Recommendation Report for Planning Permission for Works or Extension to a Dwelling

REF NO: FG/89/22/HH

LOCATION: 4 East Mead
Ferring
BN12 5EA

PROPOSAL: Single storey rear extension.

FRONT SOUTH ELEVATION
PROPOSED ELEVATIONS
Scale 1:100

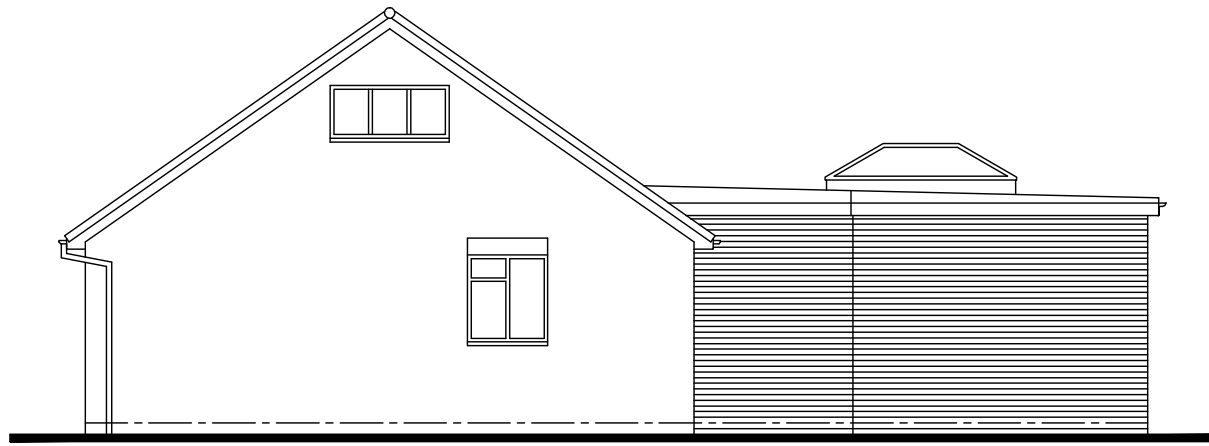
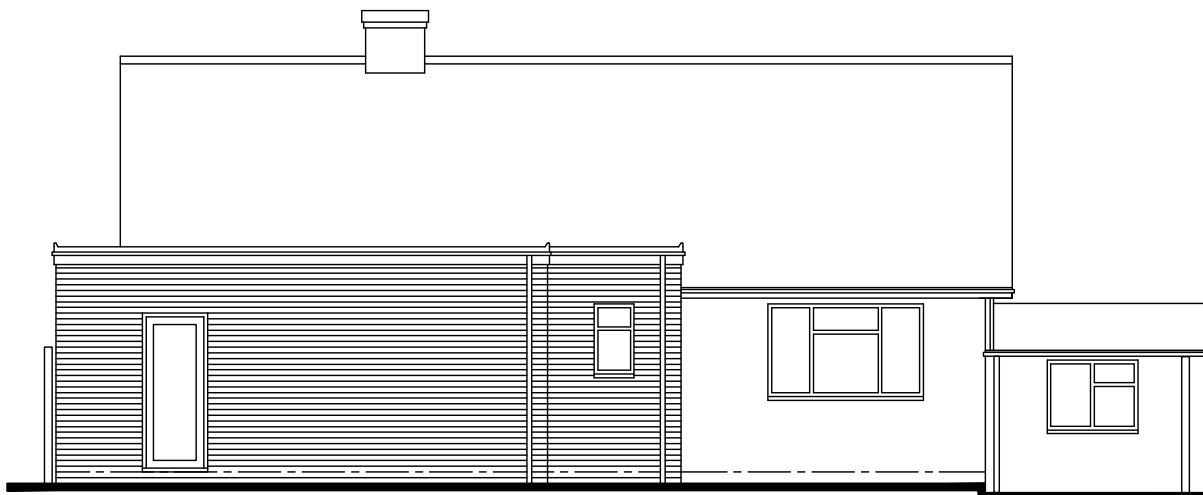
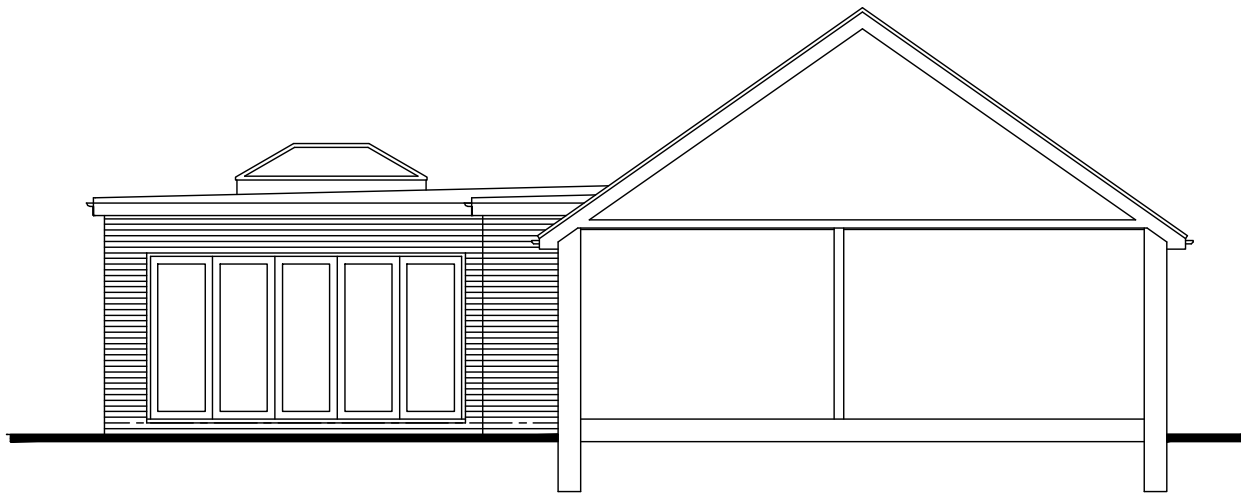
The proposed single storey rear extension is to be approx. 6m in depth and 6.5m in width with eaves at a height of 3.1m. It is to feature a shallow pitch flat roof design and would rise above the existing boundary fence 2m boundary fence by approx. 1.1m. The flat roof design would have benefitted from sitting below the existing roof eaves. However, as the existing roof eaves sit at a low height and the extension is not considerably taller, it remains acceptable, and any harm is not sufficient to be a grounds for refusal. The scale of the extension is relatively large relative to the host dwelling but remains visually subservient.

A brickwork finish matches the existing dwelling and a series of white coloured uPVC and Aluminium fenestrations are appropriate choices that help to blend the design of the extension with the host dwelling. The proposal is sited to the rear of the property and would have limited to no views from the wider street scene and as such, would have no adverse visual impact on it.

PROPOSED GROUND FLOOR PLAN
Scale 1:50

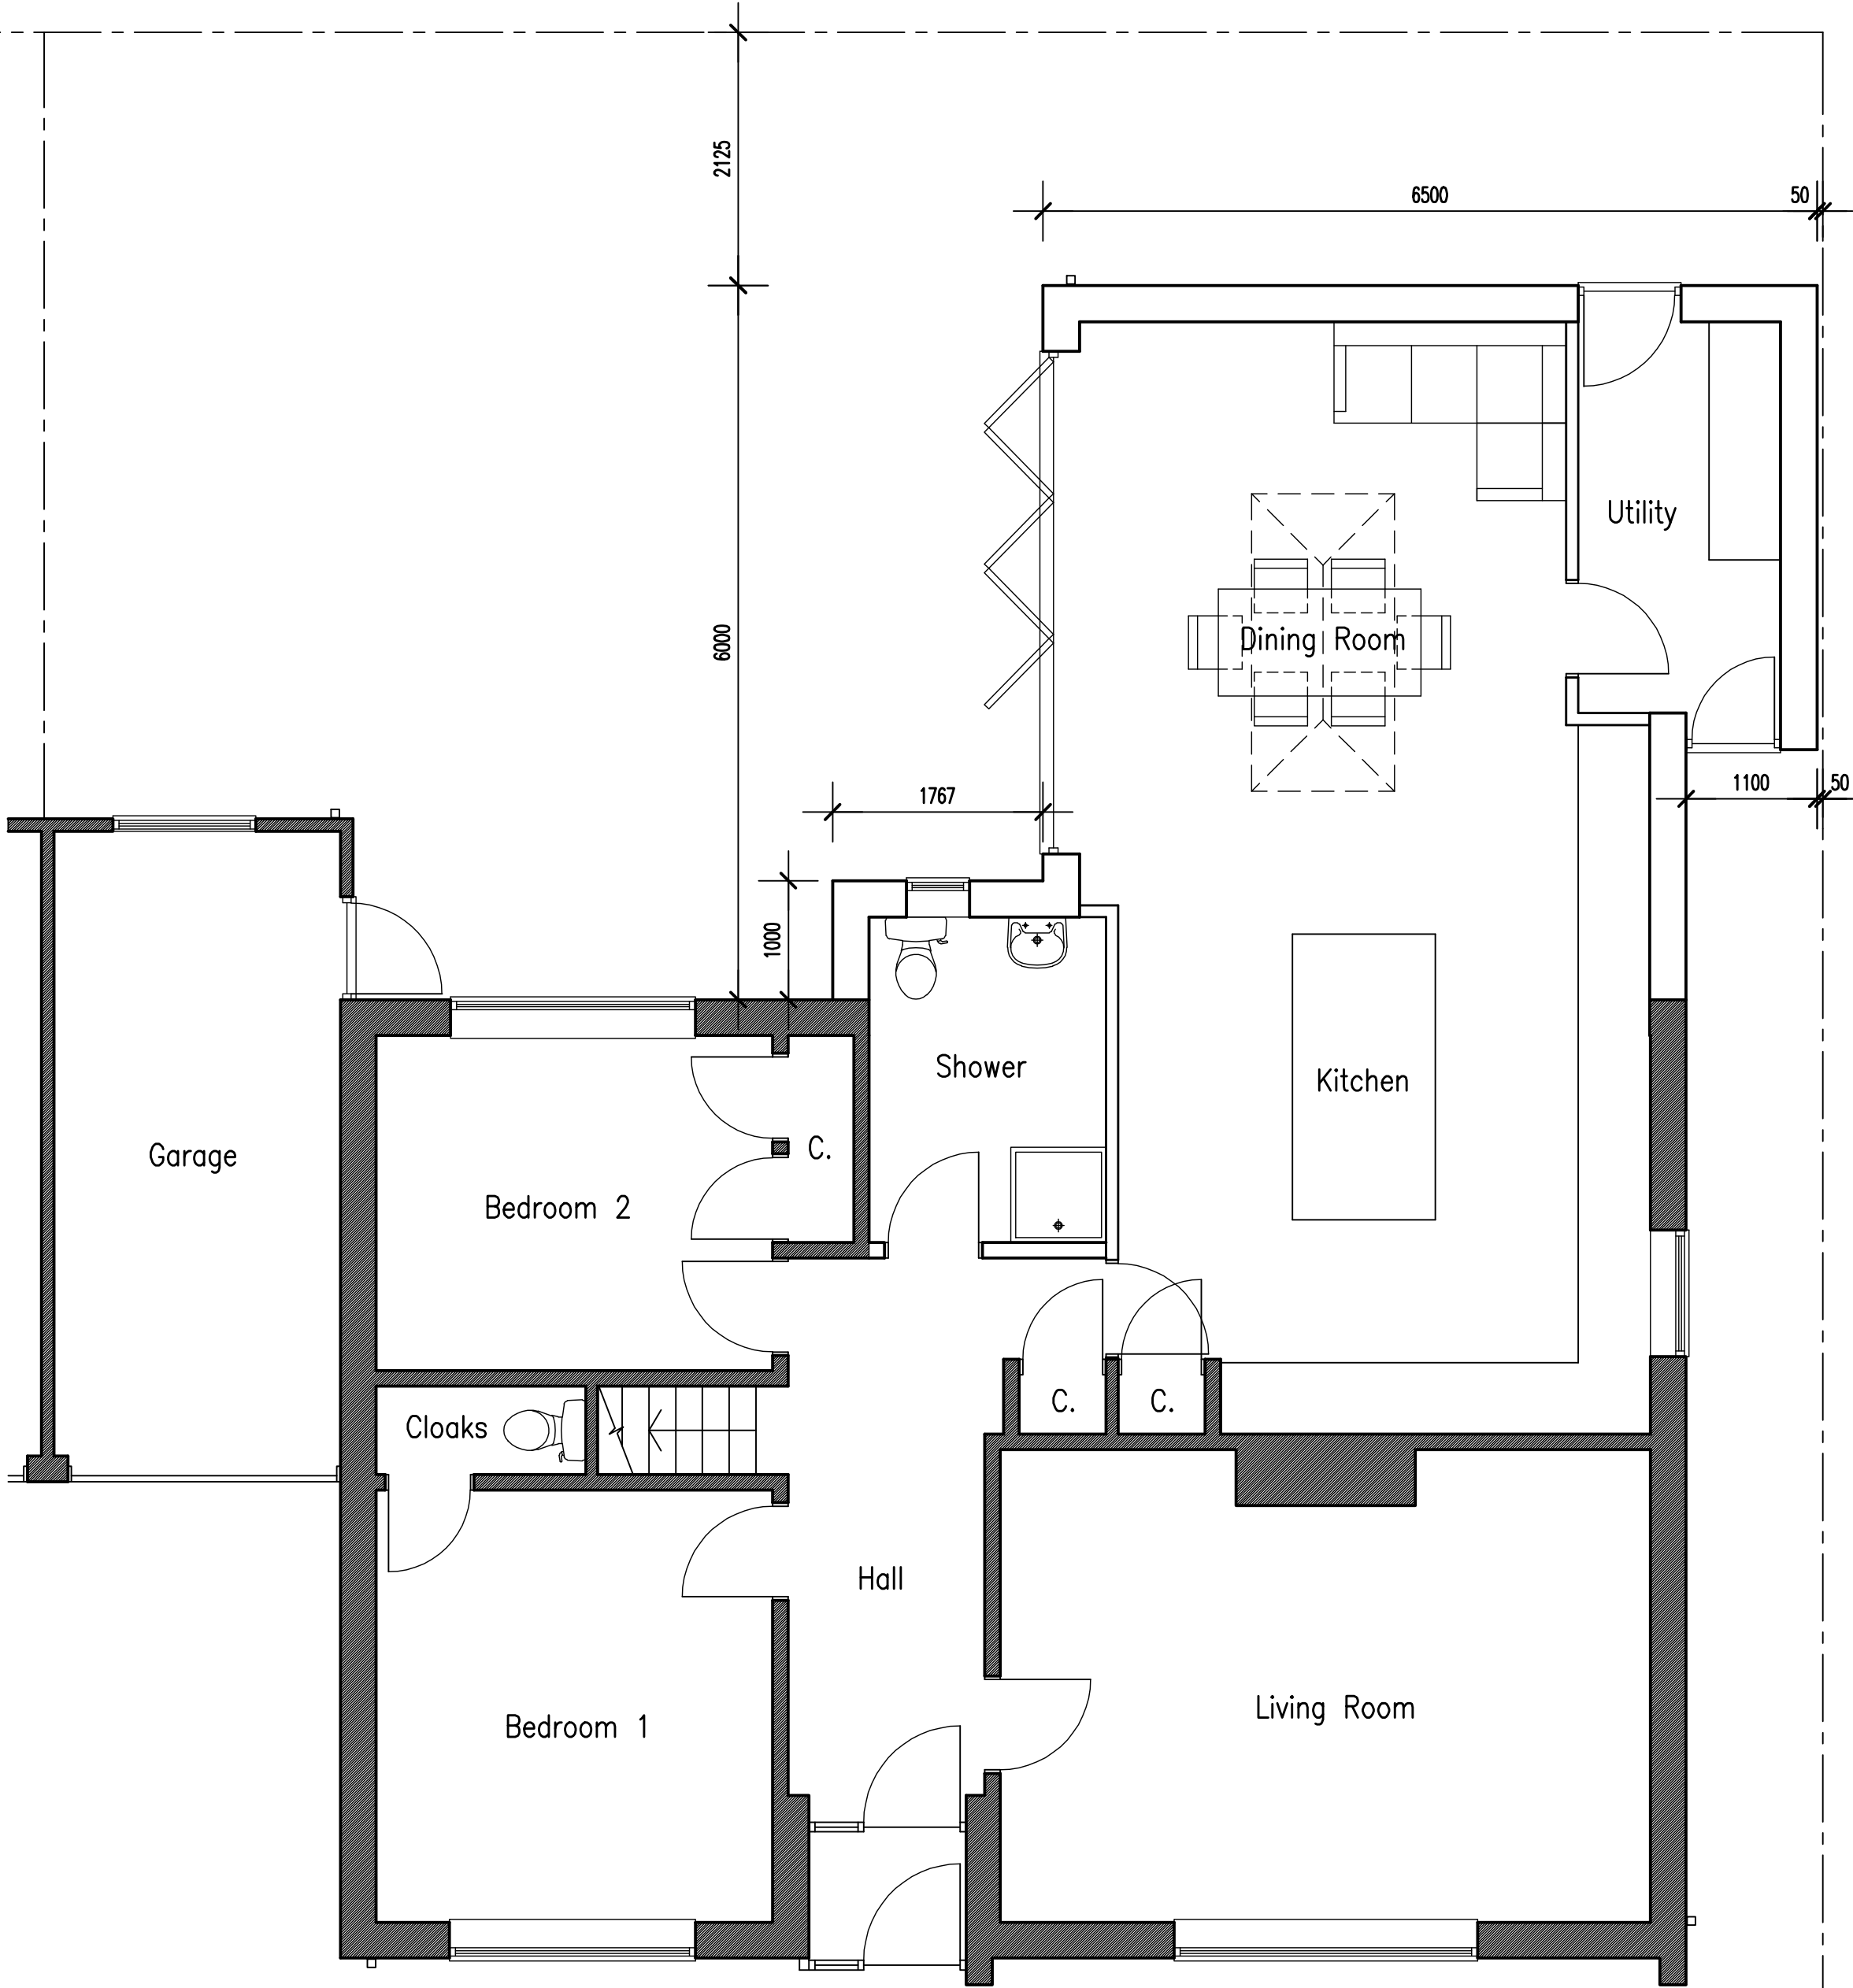
DESCRIPTION OF APPLICATION	This application seeks to erect a single storey rear extension that is approx. 6m in depth and 6.5m in width with eaves at a height of 3.1m.
----------------------------	--

The scale and siting of the proposal, despite being large and virtually meeting the East (side) site boundary, are such that there is no intersection the 45- degree light accessibility lines from the closest rear viewpoint of the neighbour dwelling (No.3). There will also be no significant intersection of the 60- degree rear sightline from the same closest rear viewpoint as the furthest extent of the extension will meet the 60- degree line. Additionally, the separating boundary treatment between No.4 and No.3 features a 2m high boundary fence and significant vegetation. The height of the extension will not impact the living conditions of No.3 further than that which is already achieved. There will be no significantly adverse impacts by way of overshadowing or overbearing on any neighbouring properties.
